NORTH LINCS S51 ADVICE – EST INPUT – 12 April 2022

Environmental Statement (ES) (Volume 6)

CRS EPSG 27700
CRS Name British National Grid
Scale 40,000
Drawing No NLGEP-ERM-XX-XX-DR-Z-0016
ArcMap File

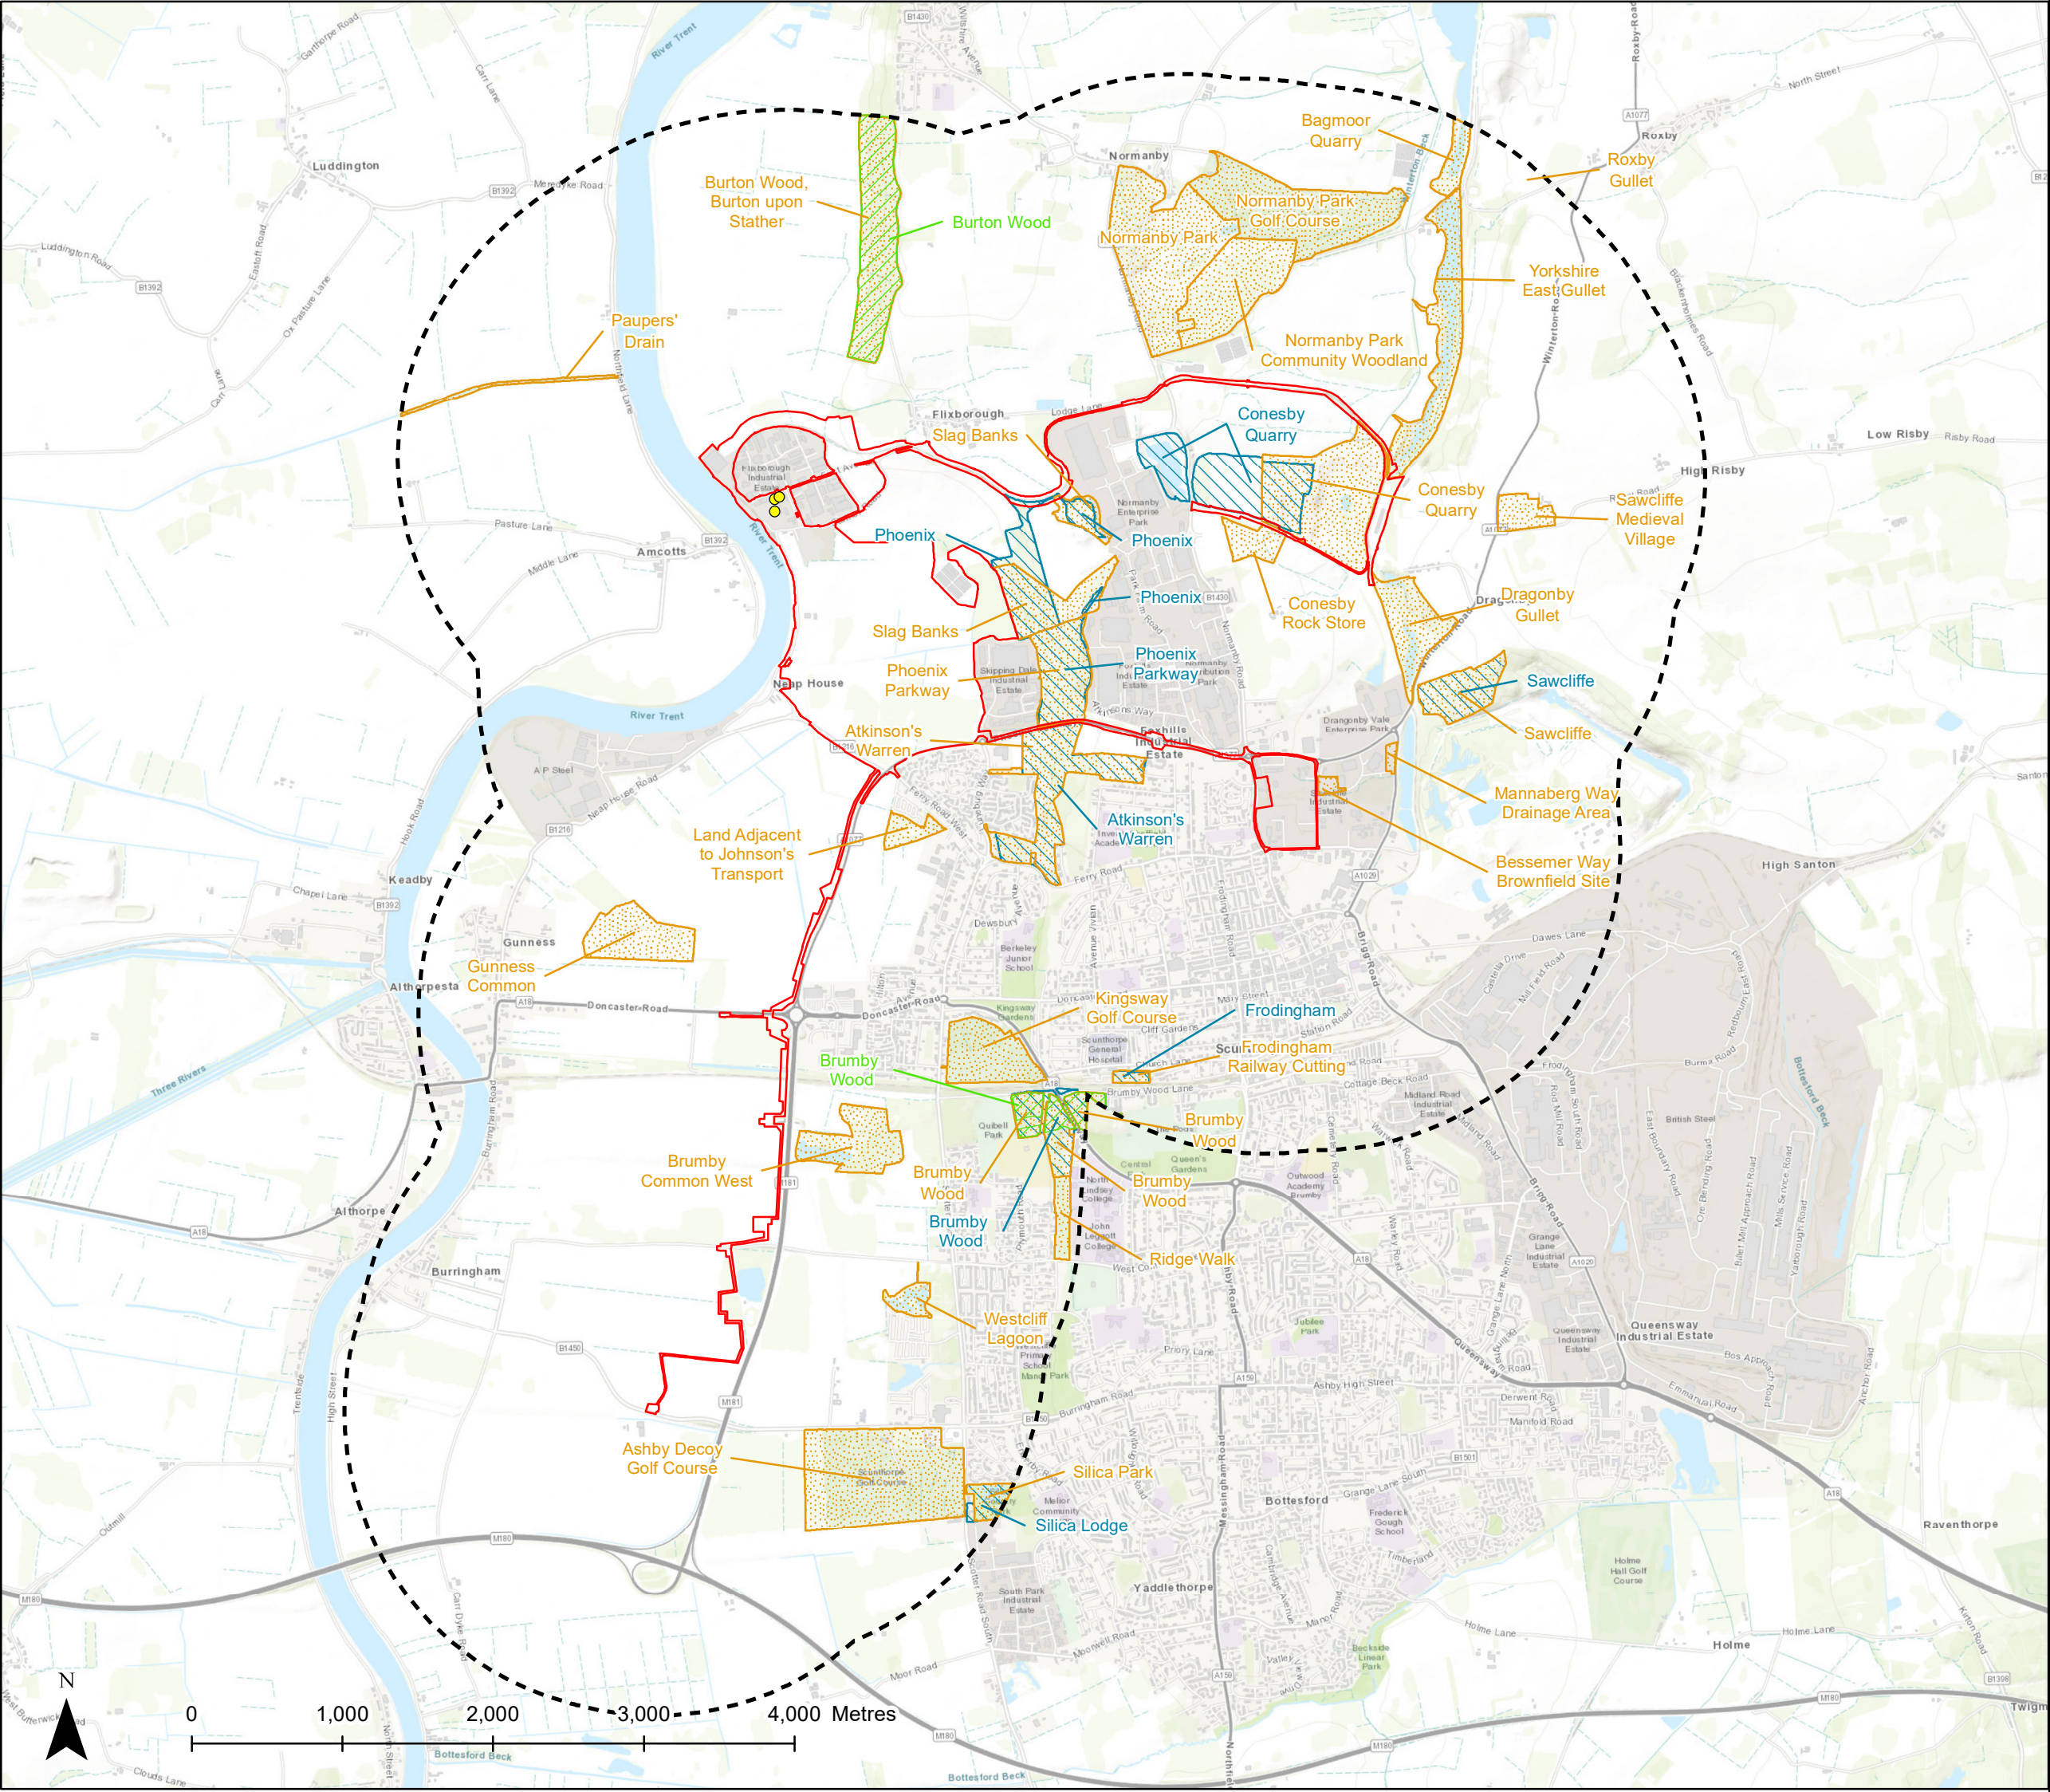
A number of statutory and non-statutory designated sites of local ecological importance are not shown on the plan illustrating Locally Important Ecology Designations within 2km of the Emissions Source (Drawing Number NLGEP-ERM-XX-XX-DR-Z-0016). The plan shows sites within 2km of the emissions' source (the stack) and does not extend across the full area covered by the application site eg sections relevant to the proposed district heat network and railway reinstatement are partially excluded. ES Chapter 10 Ecology and Nature Conservation and ES Chapter 18 Cumulative Effects identify additional statutory and non-statutory designated sites within a 2km area taken from the application site boundary (rather than the emissions source) that are not identified on Drawing Number NLGEP-ERM-XX-XX-DR-Z-0016. The Applicant is advised to ensure that the plan supported in support of Regulation 5(L)(i) encompasses the full application site and accords with the ES.
